Submissions Report
Sydney Olympic Park new high school
SSD-11802230

On behalf of
NSW Department of Education
April 2022

This Submissions Report has been prepared by Mecone NSW Pty Limited on behalf of the NSW Department of Education (DoE) to support the proposed Sydney Olympic Park new high school (SSD-11802230).

NOTE:
1. REDUNDANT LINEMAKING, SIGNAGE AND ROAD SIDE FURNITURE TO BE REMOVED.

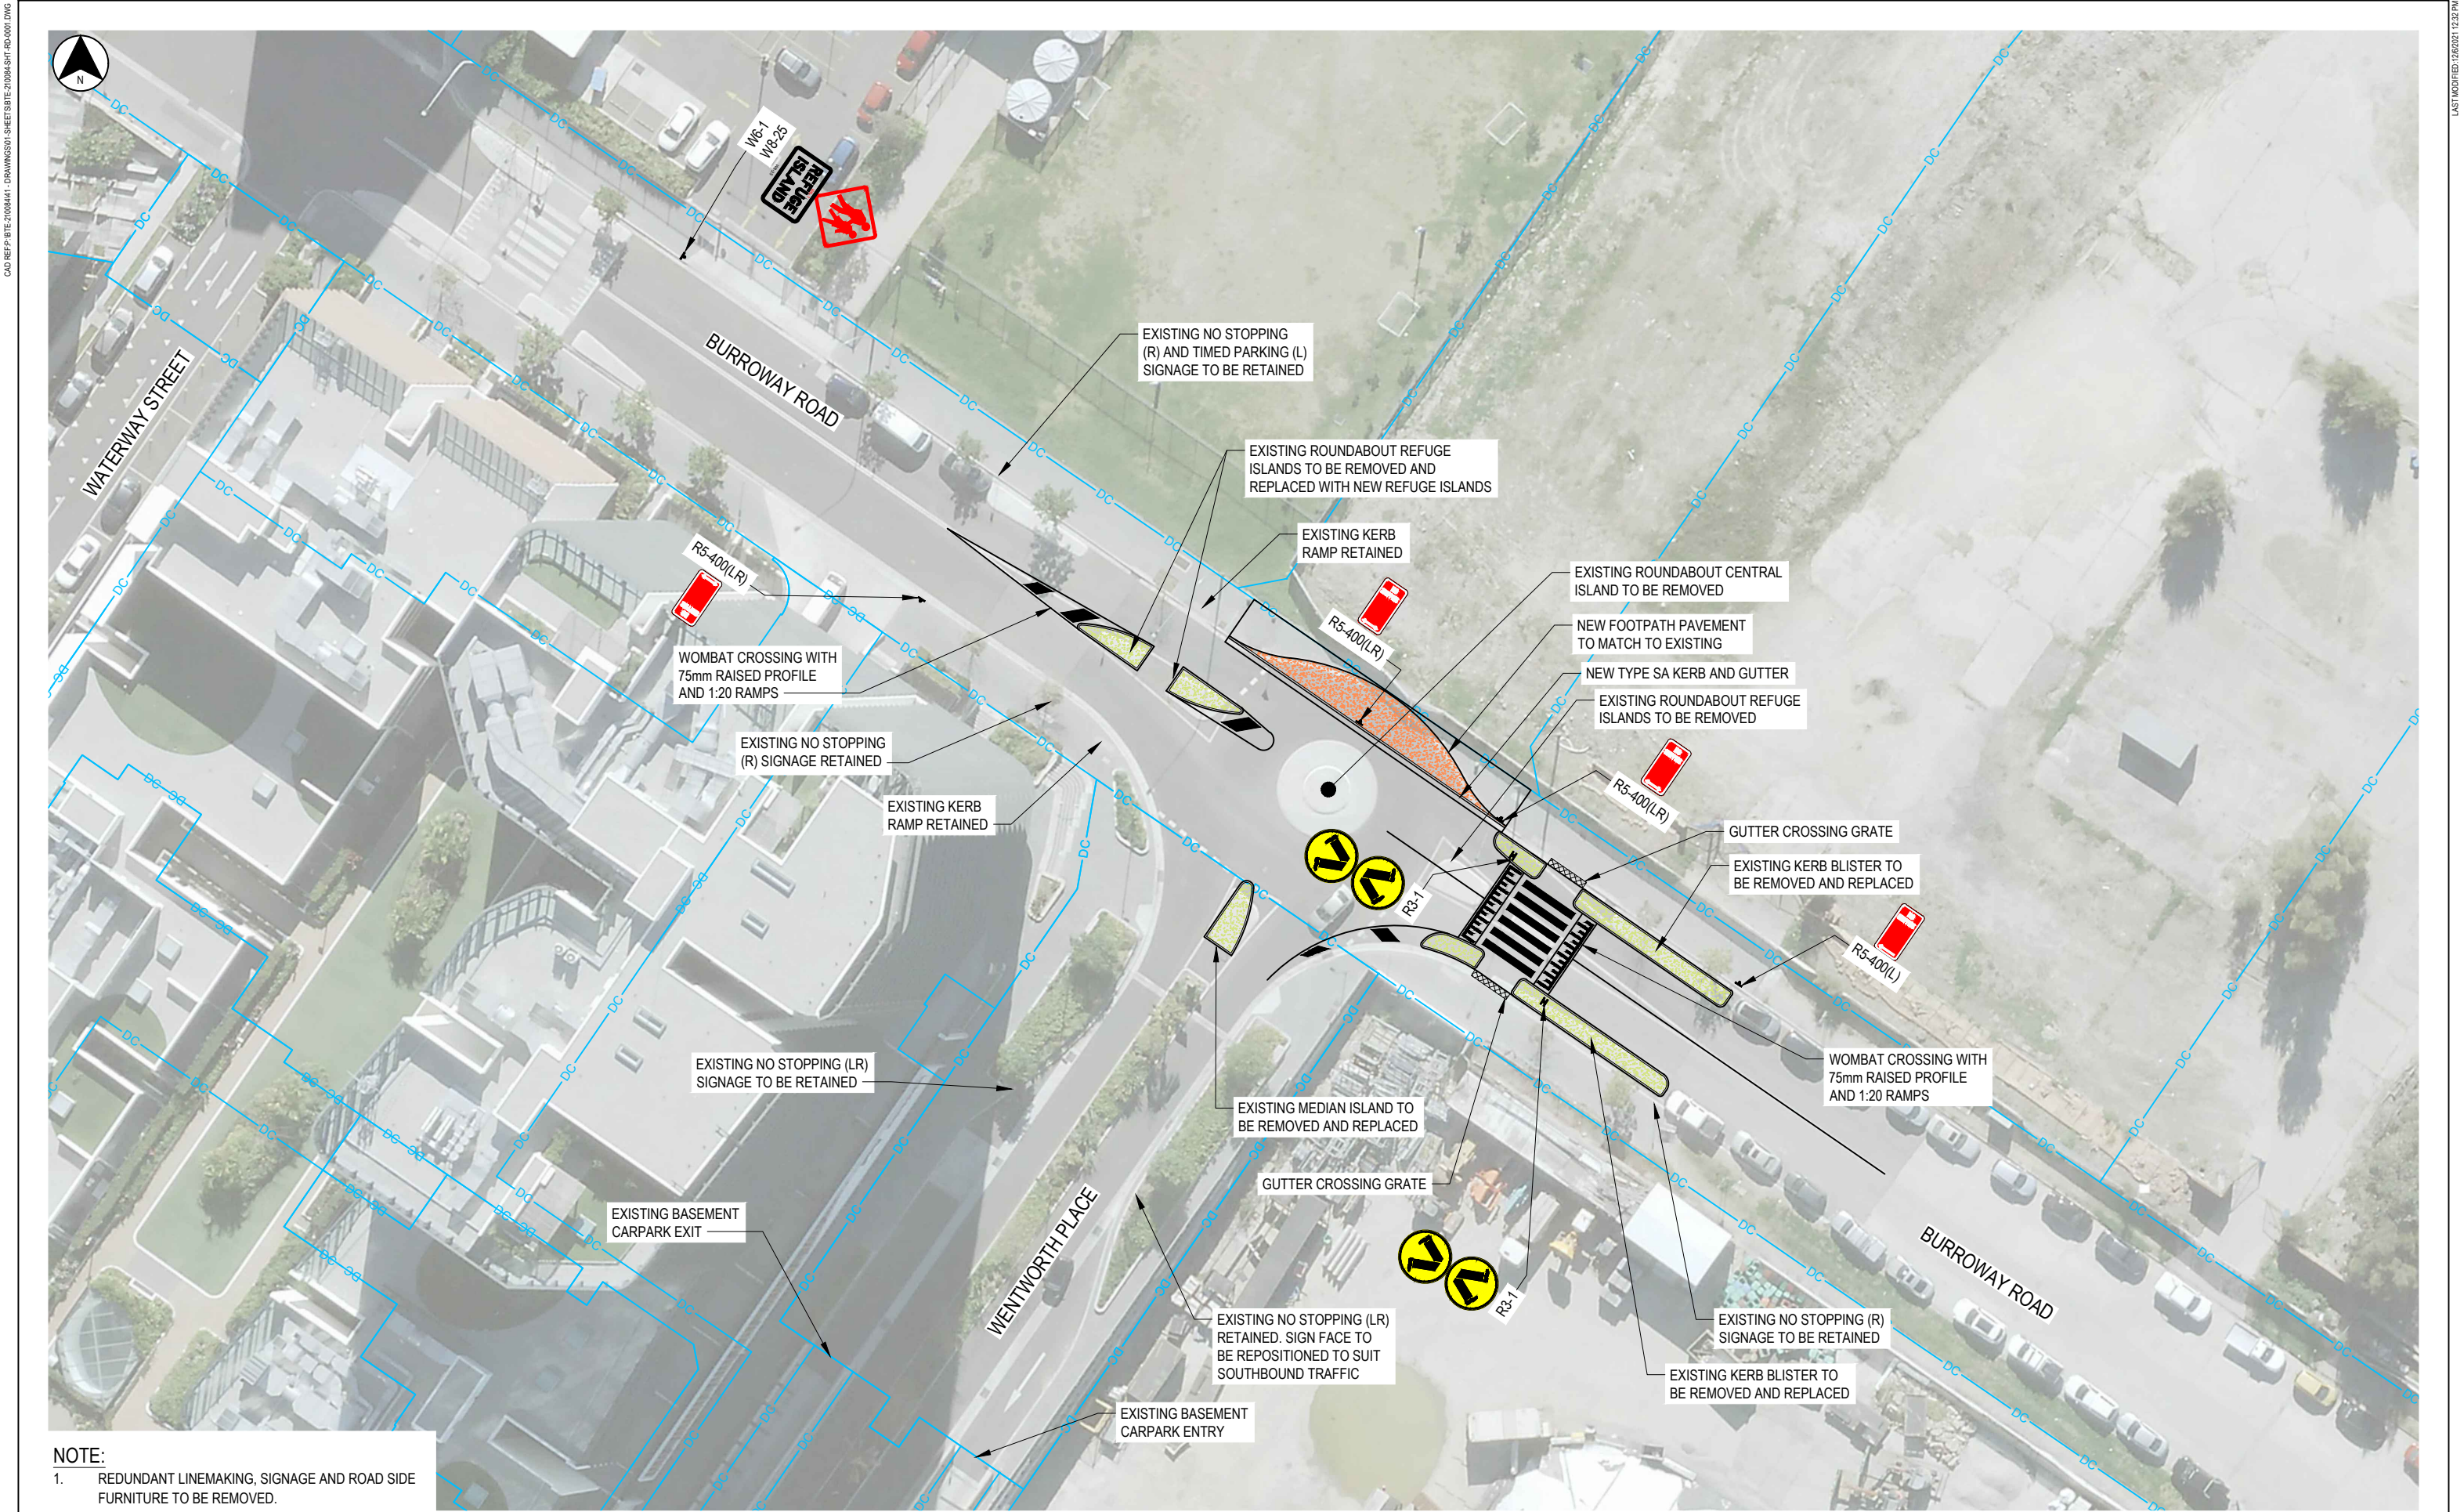
<p>Demonstrate that the footpath width on Burroway Road adjacent to the roundabout and on site bicycle parking is sufficient to cater for the expected pedestrian demand and complies with relevant standards.</p>	<p>SINSW is proposing to reconfigure the roundabout to a give-way junction that will provide an increased footpath width at this location. The footpath width will exceed 1.2m width and therefore meet accessibility standards.</p> <p>Refer to SCT's letter at Appendix 2 for further discussion.</p>
<p>Further consultation should be undertaken with TfNSW and bus operator(s) to confirm what additional bus services may be required to satisfy the demand generated by the school.</p>	<p>SINSW consulted with TfNSW bus planners on 30 November 2021 and confirmed the following:</p> <ul style="list-style-type: none"> • TfNSW regularly reviews bus services and will provide additional bus services as required by the growth. • As students tend to travel in the opposite direction to the peak travel, TfNSW believes there is spare capacity in the bus system. • TfNSW will be provided with projected enrolment figures to be included in annual bus service planning processes.

Proposed change	Reason for change
Existing Burroway Road roundabout changed to a T-intersection (give-way junction, and raised threshold zebra crossing on the southern side of the intersection removed)	<p>The proposed T-intersection in lieu of the existing roundabout allows the footpath to be increased in width to a minimum of 1.2m to eliminate the previous 500mm pinch point and provide compliant pedestrian access along the northern side of Burroway Road.</p> <p>While a roundabout provides some limited benefit for traffic to conduct U-turns, the proposed T-intersection provides a higher quality crossing experience for students.</p> <p>The removal of the island and midblock islands makes for a more straightforward design of the proposed raised threshold zebra crossings, which are more challenging to install adjacent to a roundabout.</p> <p>The raised threshold zebra crossing on the southern side of the intersection (on Wentworth Place south of Burroway Road) is not feasible to construct as there is insufficient sight distance to the exit ramp from Marina Square. Also, the provision of wider footpaths to the north as part of the give-way intersection mean that this crossing is not required. All proposed pedestrian crossings are identified in the Public Domain Plan at Appendix 15.</p> <p>This has been informed by consultant input from SCT. A sketch of the proposed intersection by SCT is provided at Appendix 6. The design will be refined in consultation with Council during the Section 138 approval process.</p>

LANDSCAPE CONCEPT DESIGN PLAN

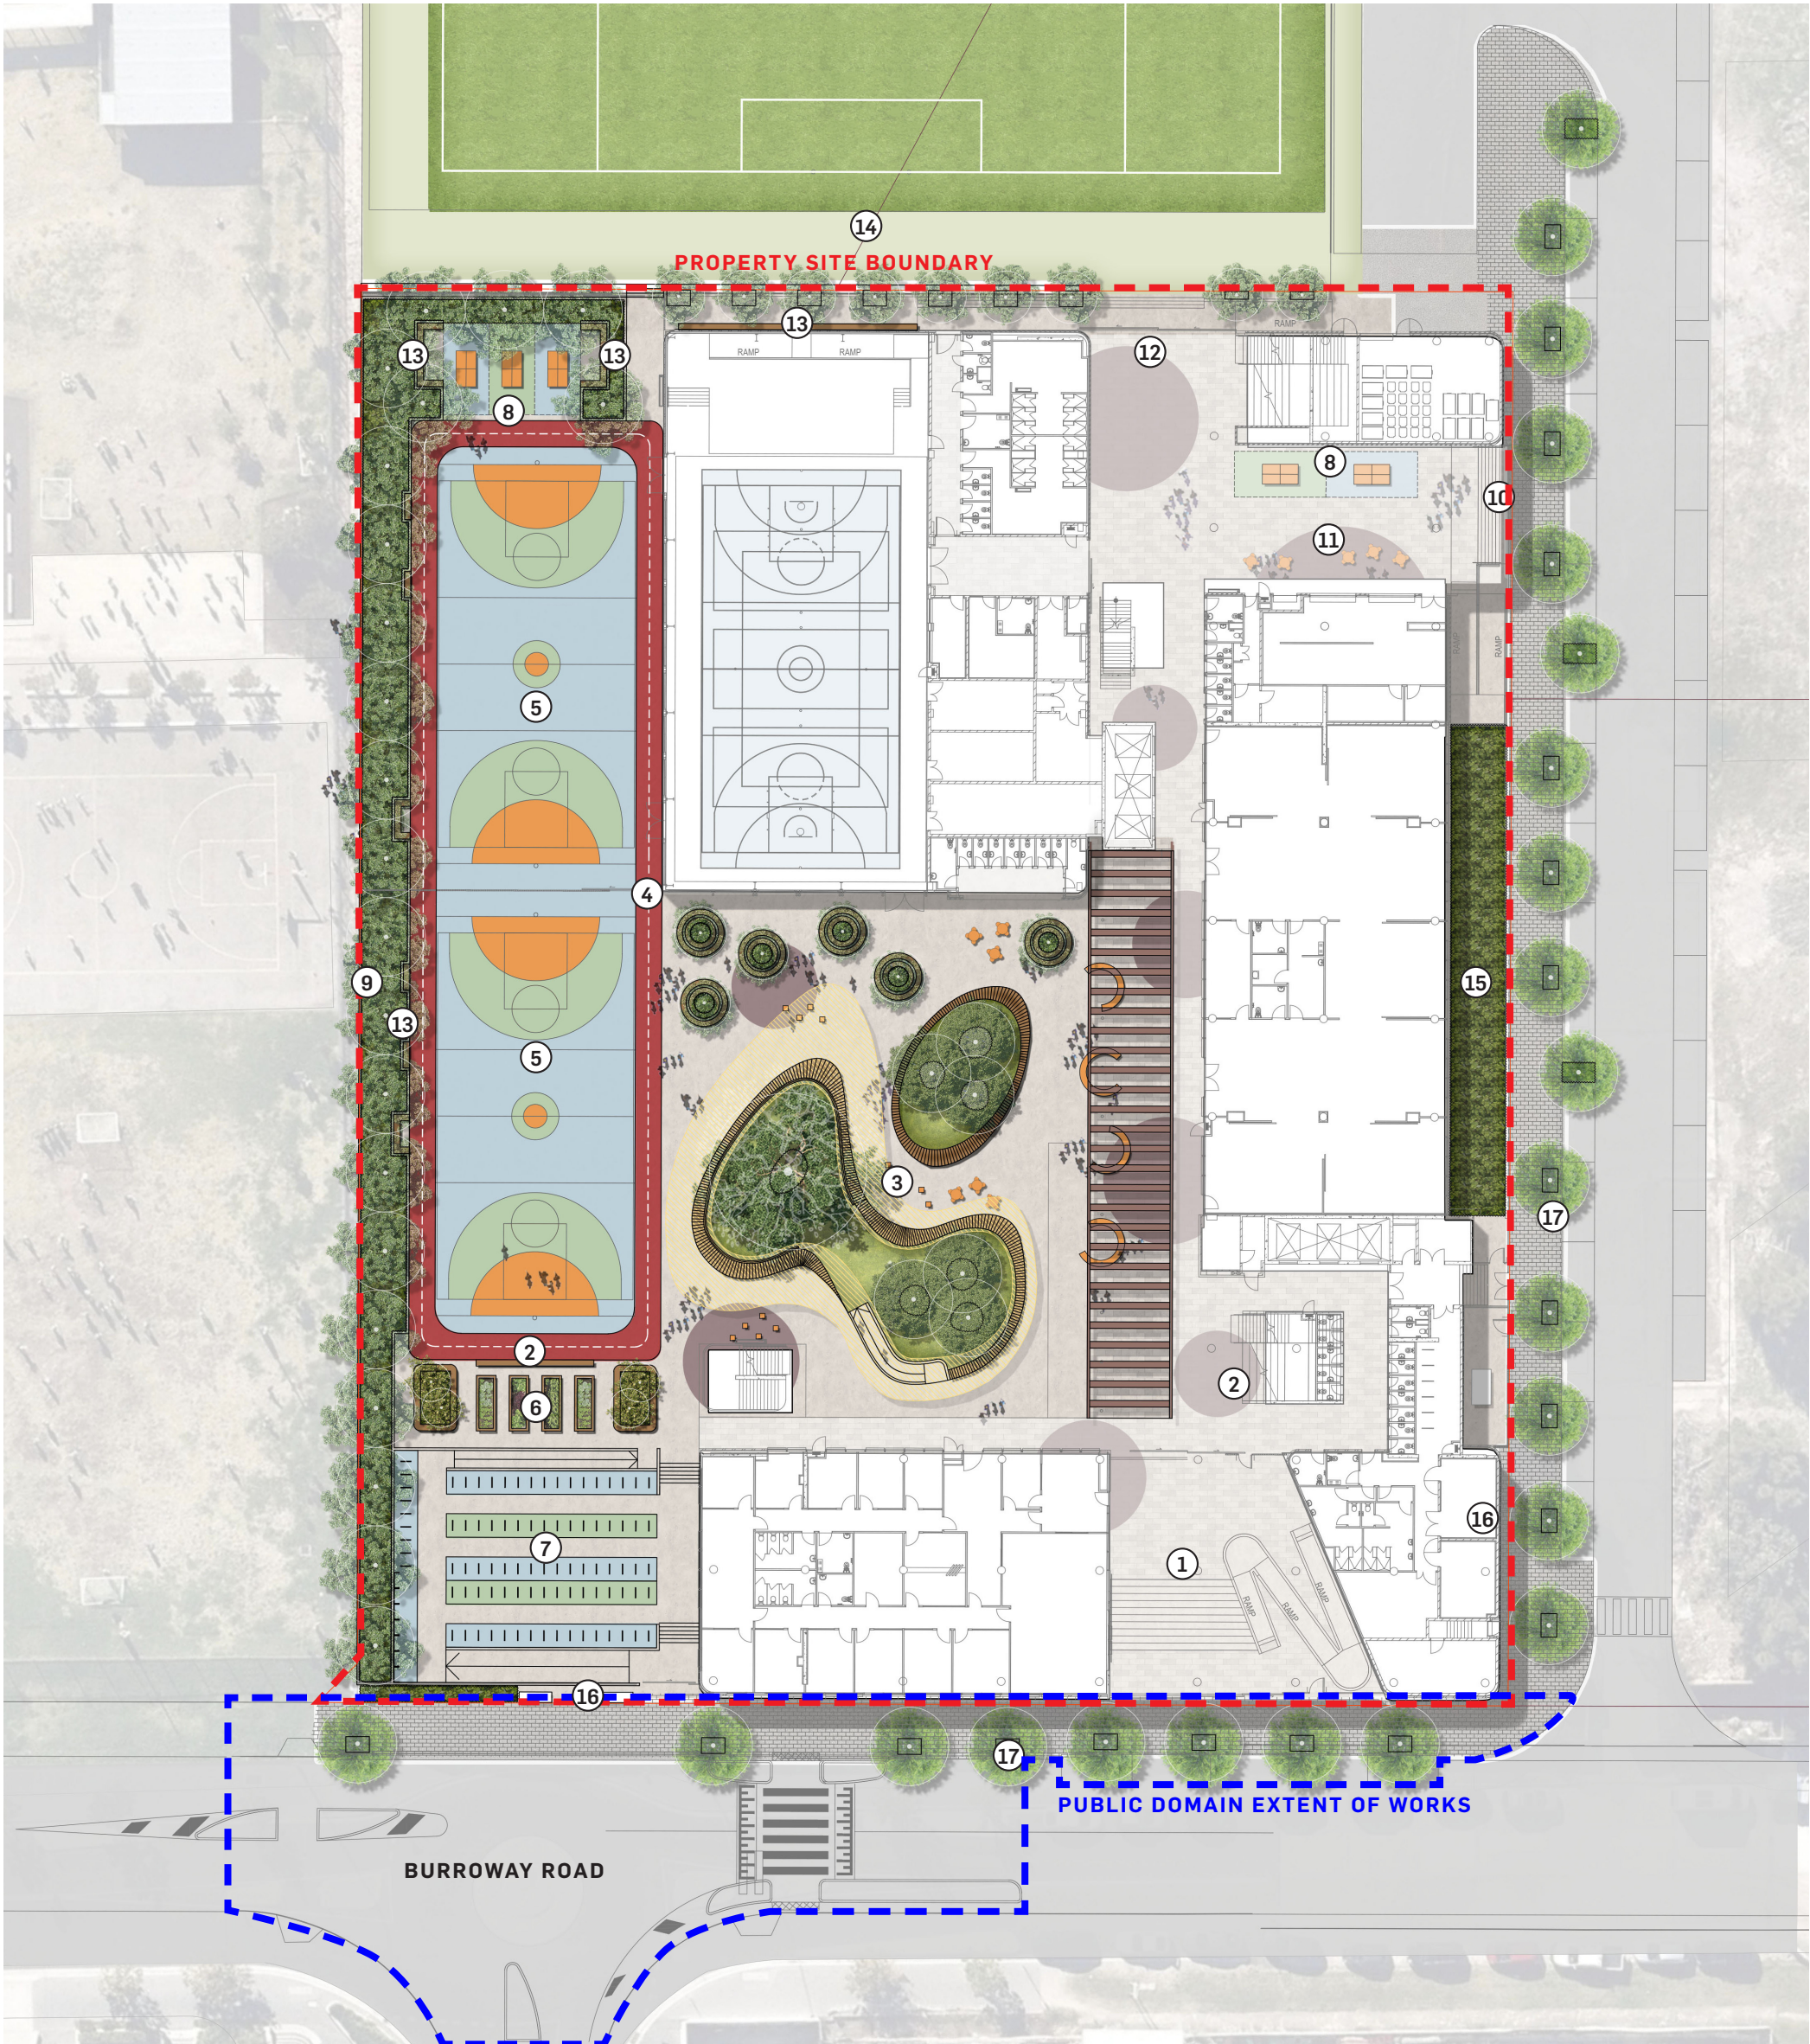
<p>The school proposal should contribute to the development of the site's street frontage public domain. The landscape drawings provided show indicative street tree locations and vague public domain design outcomes. However, clearer public domain drawings meeting the requirements set out in the Parramatta Public Domain Guidelines (PPDG) should be provided.</p>	<p>The submitted landscape drawings are considered sufficient to enable a planning assessment and determination.</p> <p>DoE would comply with standard DPE conditions regarding public domain works, which require consultation and approval from Council (via Section 138 approval) and demonstration to the certifying authority that</p>
